**WEST SUSSEX COUNTY COUNCIL
PLANNING SERVICES CONSULTATION**

SUBJECT: WA/73/17/OUT - Outline Planning Application with some matters reserved for up to 157 No. residential dwellings including 30% affordable. This application is a Departure from the Development Plan.

Land East of Wandleys Lane, and West of West Walberton Lane, Fontwell

Drawing Issue Status					
INDICATIVE - FOR INFORMATION					
LAND EAST OF WANDLEYS LANE A27 / A29 WEST ROUNDABOUT JUNCTION GEOMETRY					
Client					
WELBECK STRATEGIC LAND II LLP					
Date of 1st Issue 29.09.17		Designed JHJ	Drawn MJB		
A3 Scale 1:500		Checked GH	Approved GH

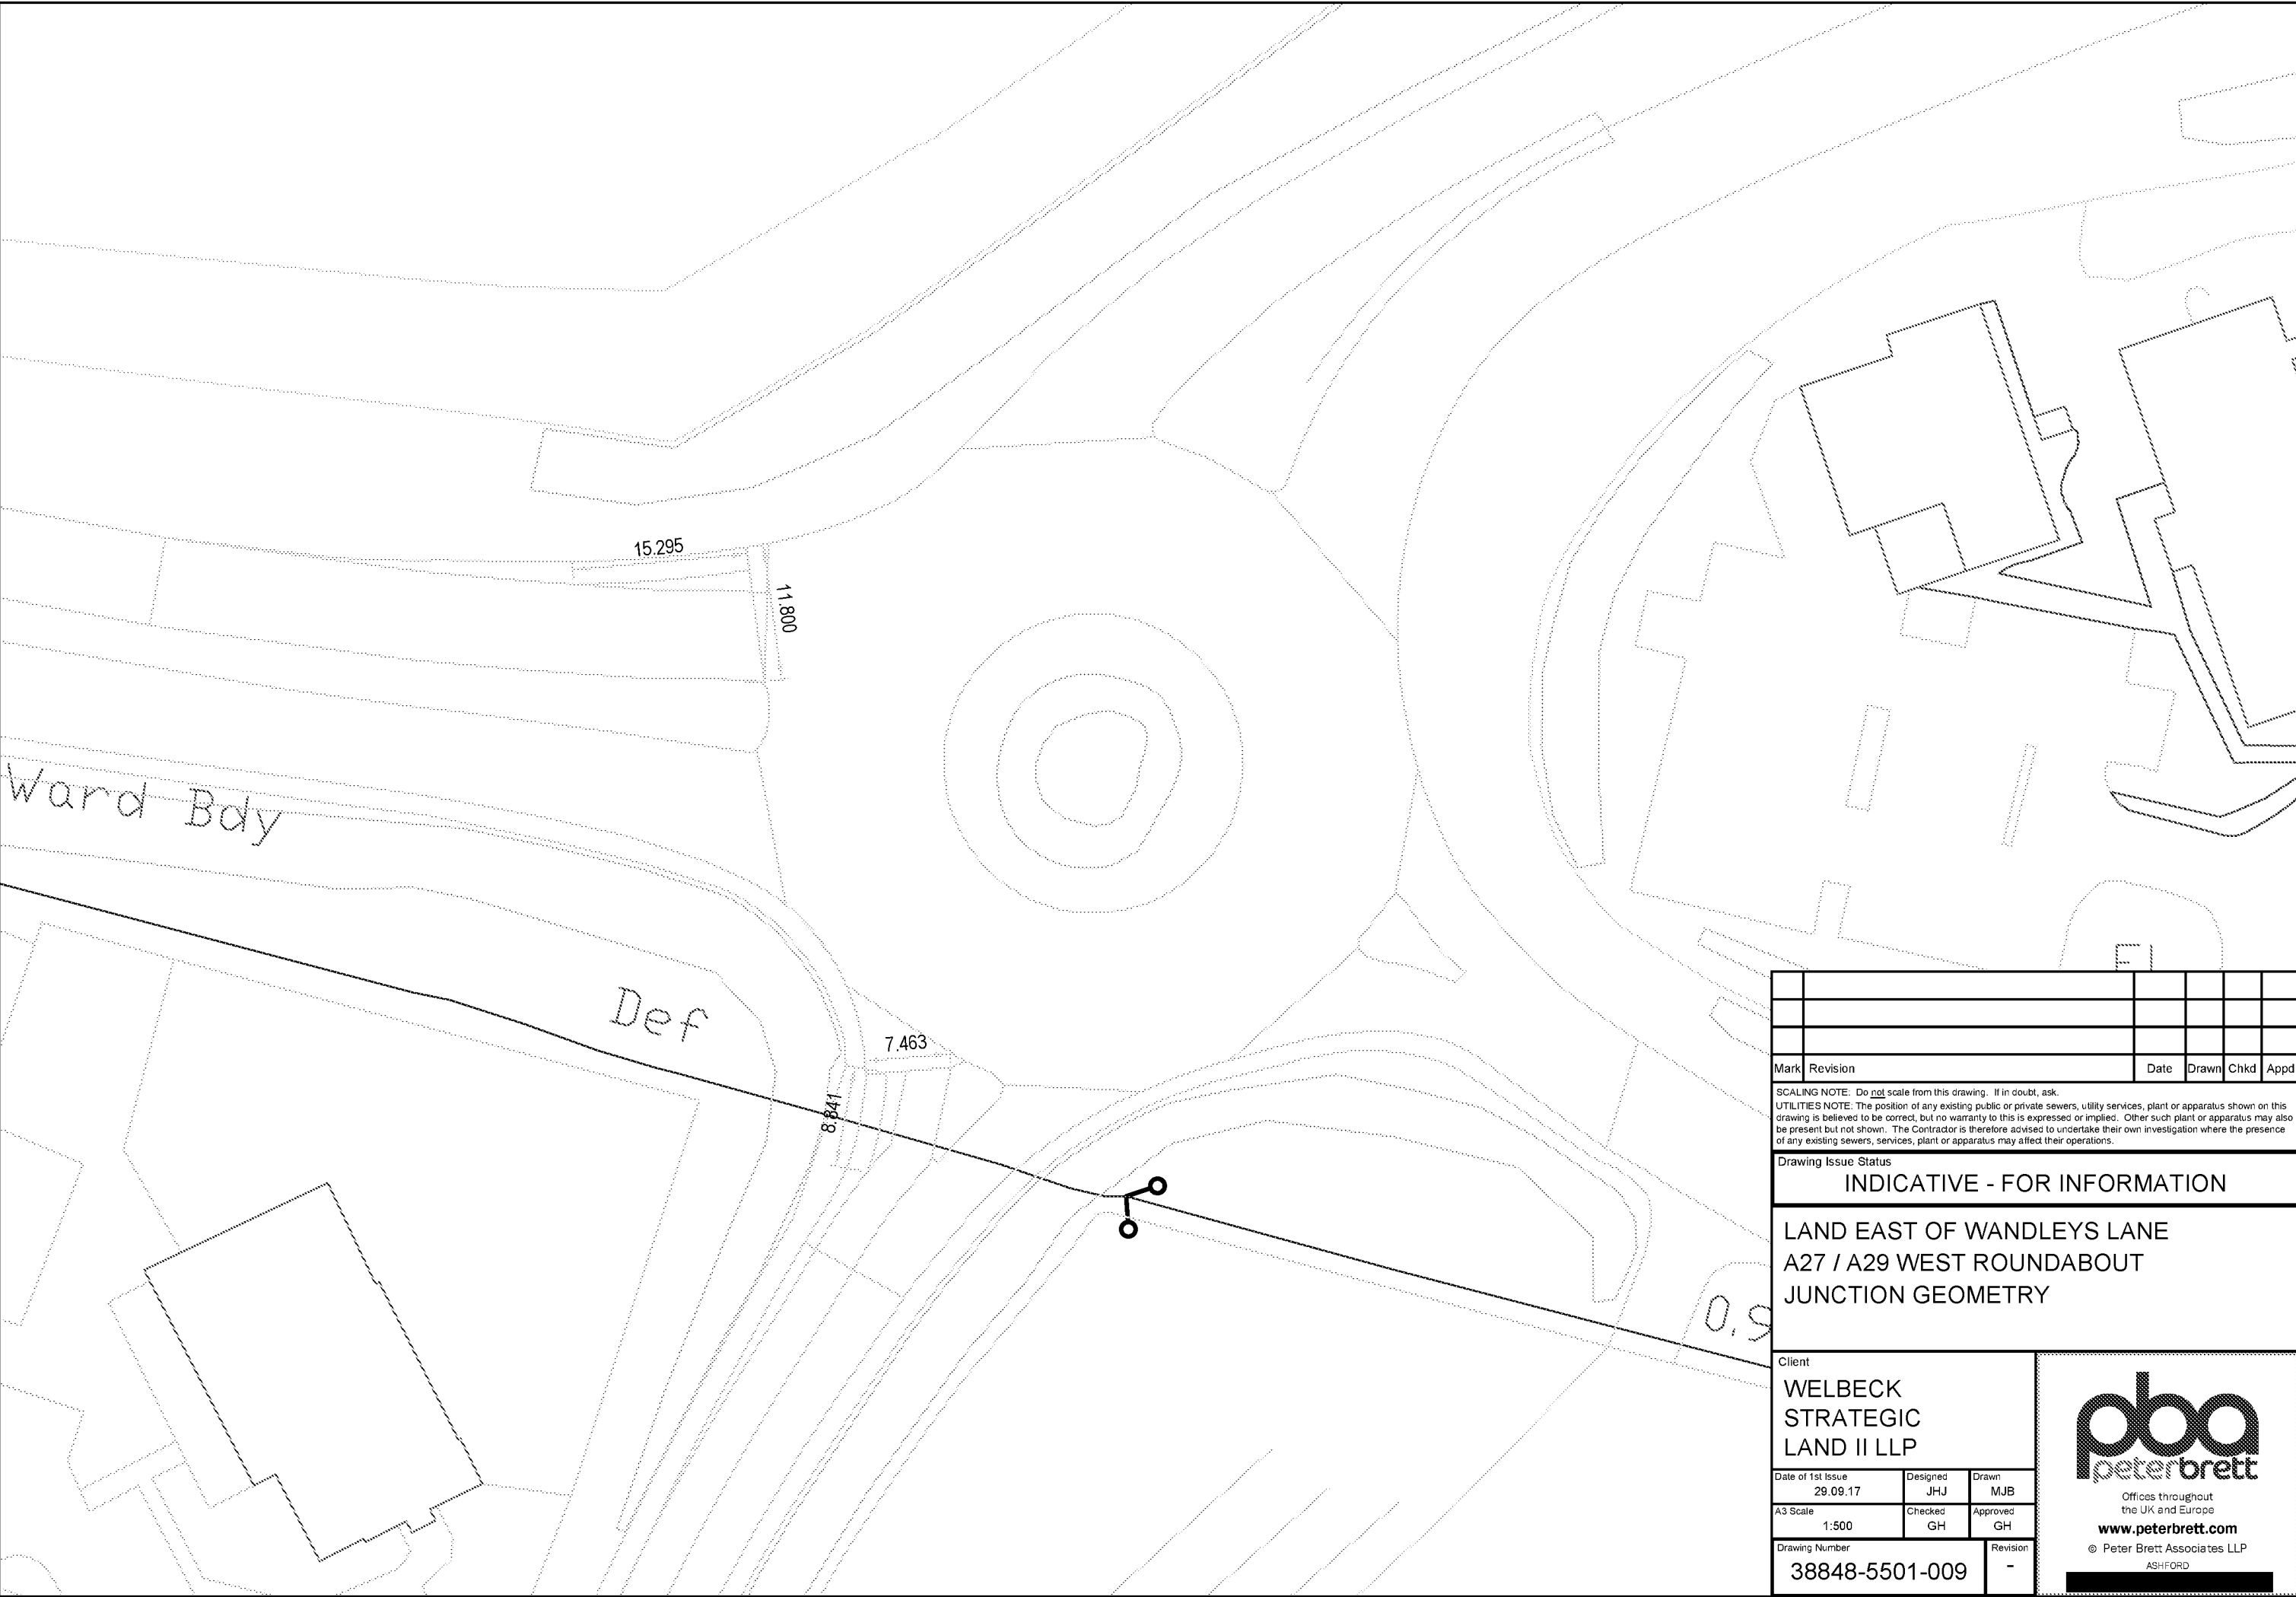
The applicant proposes the widening of the A27 east entry lanes by a total of 1.4m under the local plan scenario or the extension of the A27 east arm by 3pcus lengths under the Tye Lane scenario test. It does not appear that any design work has been provided to indicate if the improvements are deliverable.

Subject to the applicant agreeing the deliverability and the agreement of an appropriate delivery mechanism for the improvements no further concerns are raised.
